Department of Defence
Estate and Infrastructure Group

ID-EP-DLP&R/OUT/2021/BS20074212

RE: SSI-12590060 EIS REPORT – HUNTER POWER PROJECT (KURRI KURRI POWER STATION), HART ROAD, LOXFORD NSW 2326

Figure 4.4: Height at which plume vertical velocity falls below 6.1 m/s for 2 x OCGT units

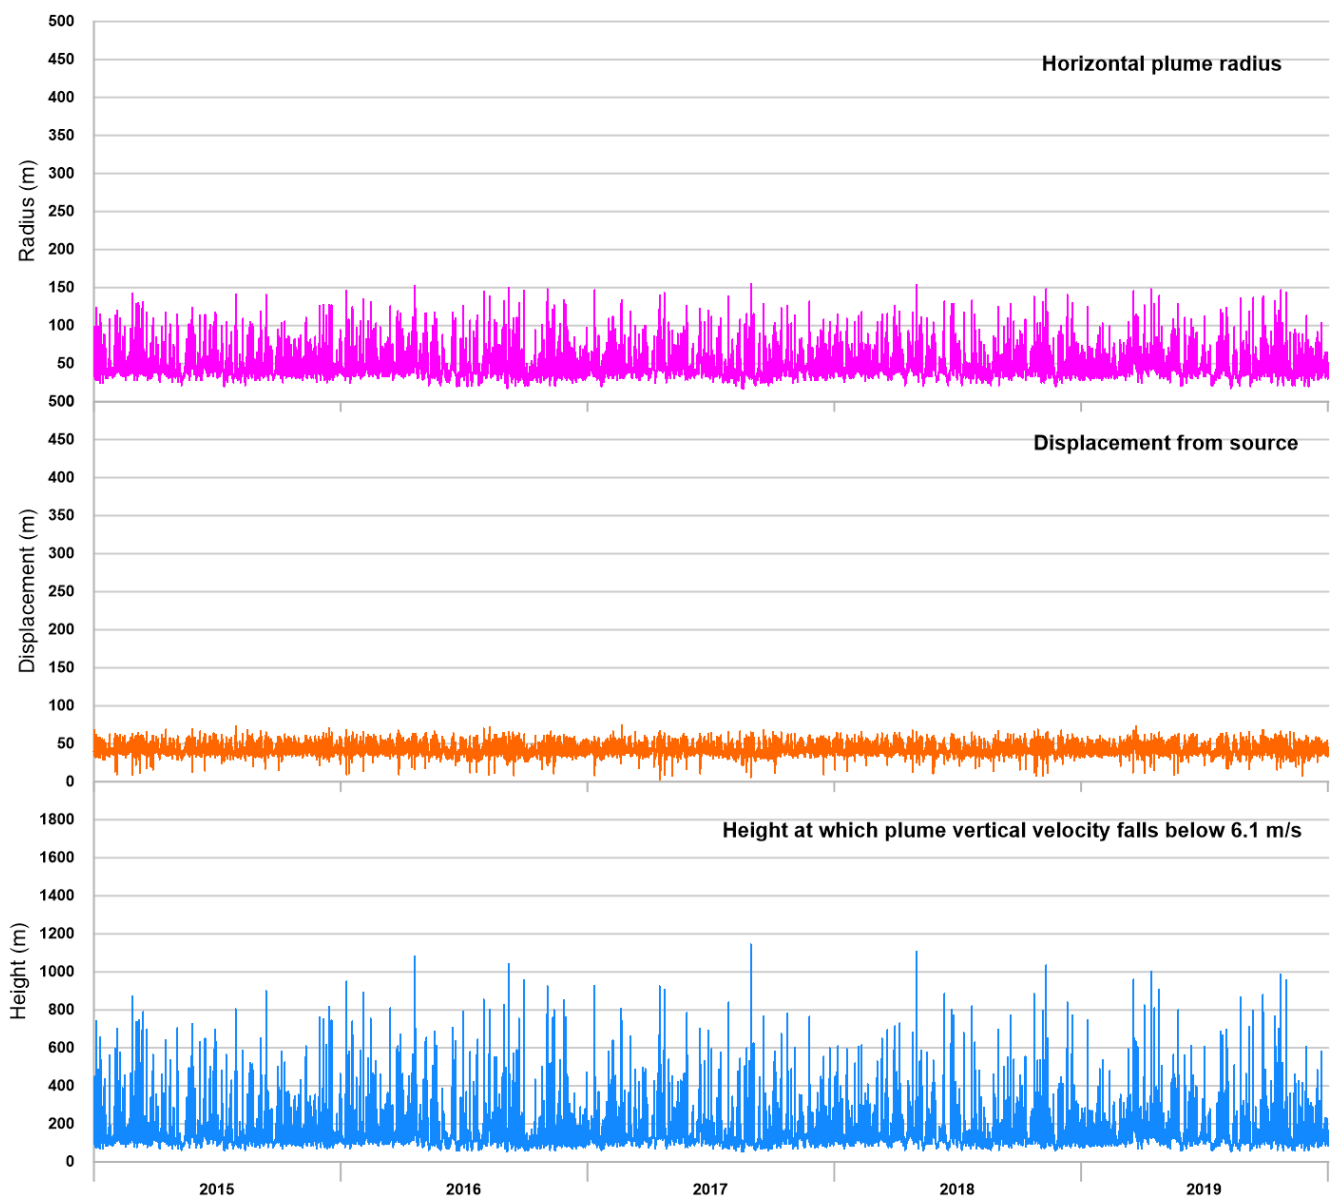
The height at which the velocity of the merged plume from the two proposed 36m high exhaust stacks falls below 6.1m/s (0.1 percent exceedance or 99.9th percentile) is 867m AHD (2845ft AHD). On this assessment, Defence considers that the construction of the power station will not adversely impact upon civil or military flying operations at RAAF Base Williamtown / Newcastle Airport, provided that the following mitigating measures are adhered to.

Defence requests that a permanent charted Danger Area is to be promulgated using Global Airspace Solutions dimensions to account for the vertical plume velocities generated from the plant. The parameters of the Danger Area will include a vertical elevation of 884 metres (2,900 feet) and a horizontal radius of 155 metres, it should include a note to avoid the Danger Area.
